Your Ref: CM/16/18/PL

Our Ref: NW/ARU/18/08A

RE Land to the rear of Bairds Farm Shop Crookthorne Lane Climping OX27 7LT

Thank you for your correspondence of 19th June 2018, advising me of a Development of a 64-bed Specialist Dementia Care Centre together with access, parking & landscaping (Use Class C2). This application is a Departure from the Development Plan & affects the setting of a Listed Building, for which you seek advice from a crime prevention viewpoint.

DEMENTIA GARDEN FEATURES

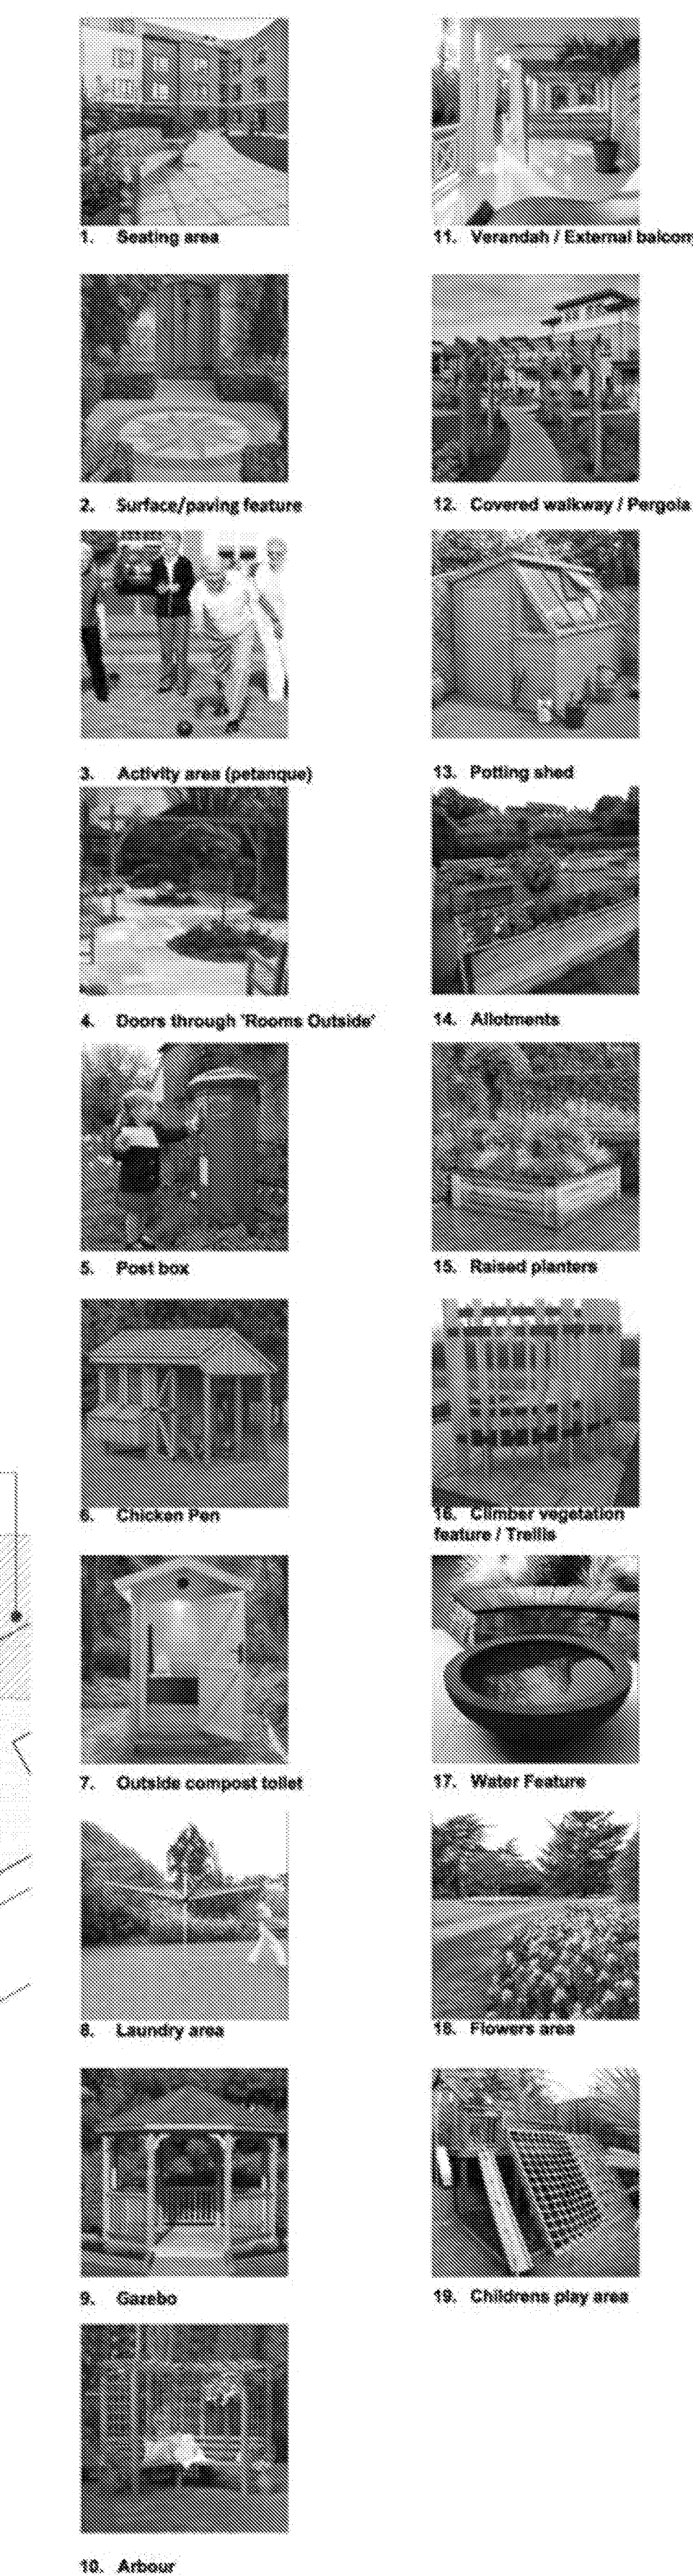
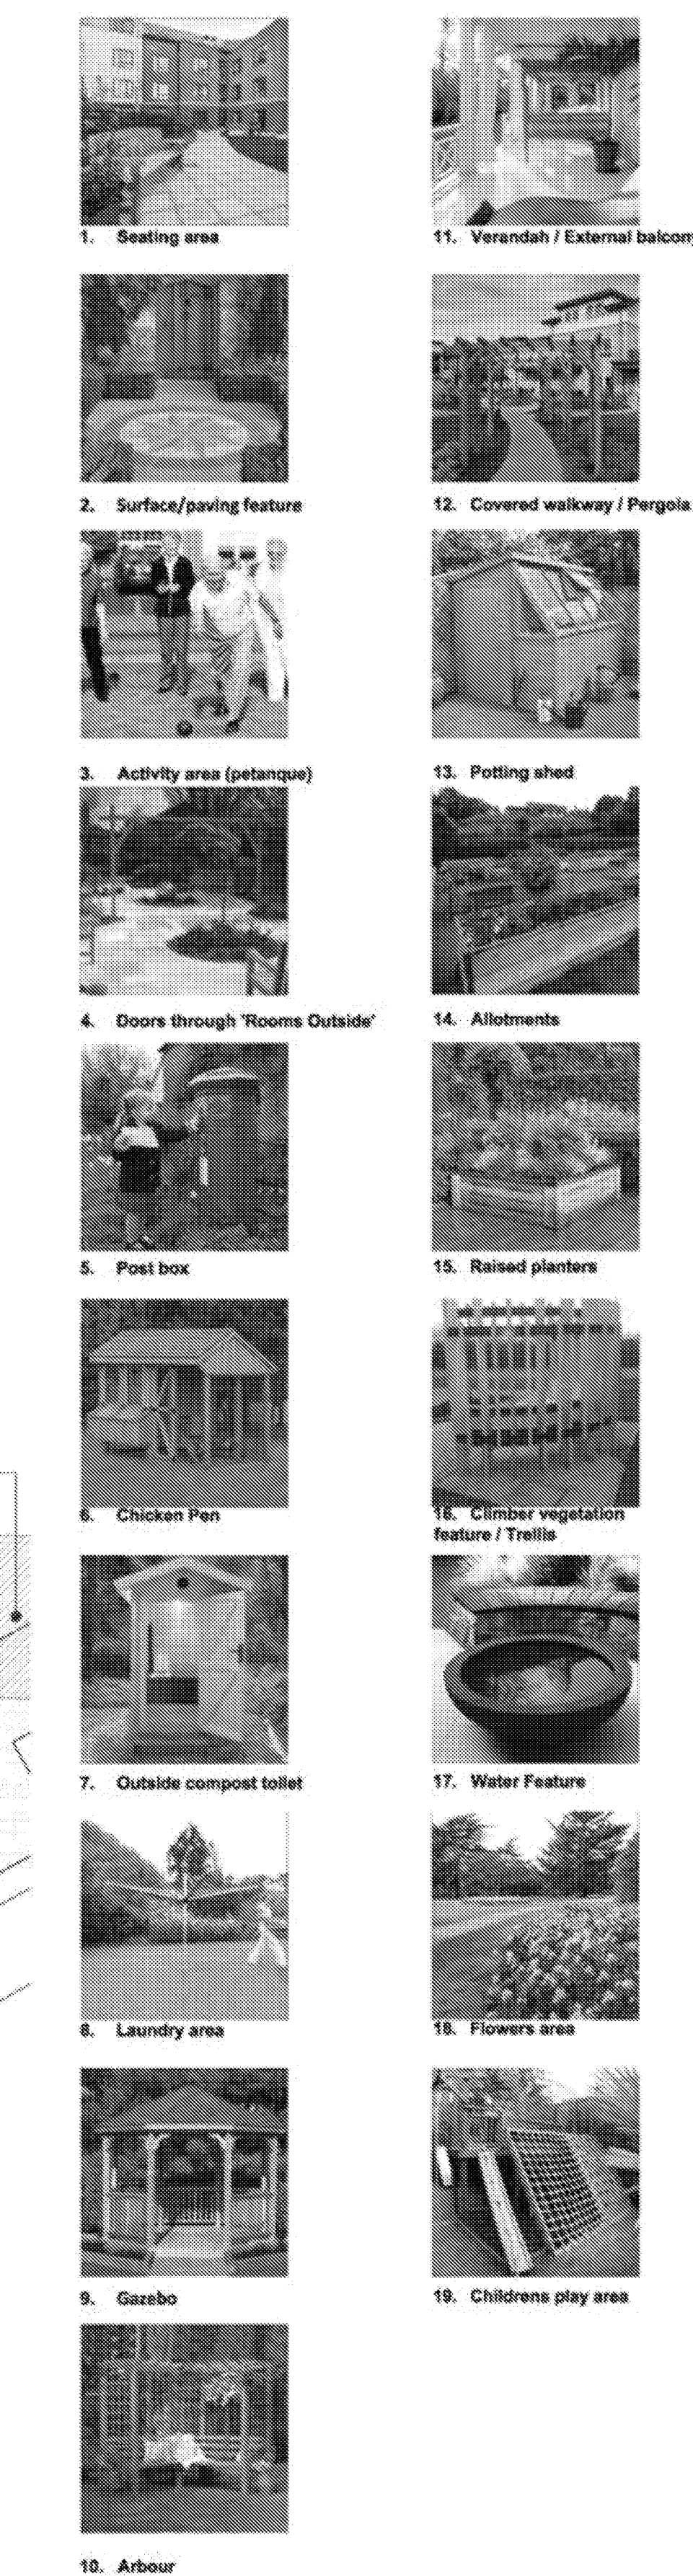
I am pleased to see that 1.8m high close boarded fence topped with 400mm of trellis will be enclosing the north west side the west side and south side of the development . I note there is no main controlled access gate required.

The eastern perimeter will have dense bushes along its length, but this does not offer protection from person or animal intrusion through holes in the hedge line. A camping field alongside the development may leave the east side potentially more vulnerable. I would recommend 1.8m high or alternatively 1.5 m high close boarded fencing topped with 400mm trellis to allow a view from the development but still provide a solid perimeter which will enhance the other perimeter security or alternatively the use of weldmesh fencing to close any gaps in the hedgerow.

The refuse store, chemical store and clinical waste store are located separately from the main building towards the car park and must have doors fit for purpose and with access control.

I would recommend that they each have switched lighting within them and are separated by solid barriers between each, which must be floor to ceiling to prevent access between any of them. I would recommend the double access doors to the refuse bin store and handyman store have controlled access with a door lock release on the internal sides to prevent unintended locking in. Given that bin store and handyman store have double doors, a door closer is to be fitted along with spring loaded automatic shoot bolts to the unlocked door to ensure it closes first.
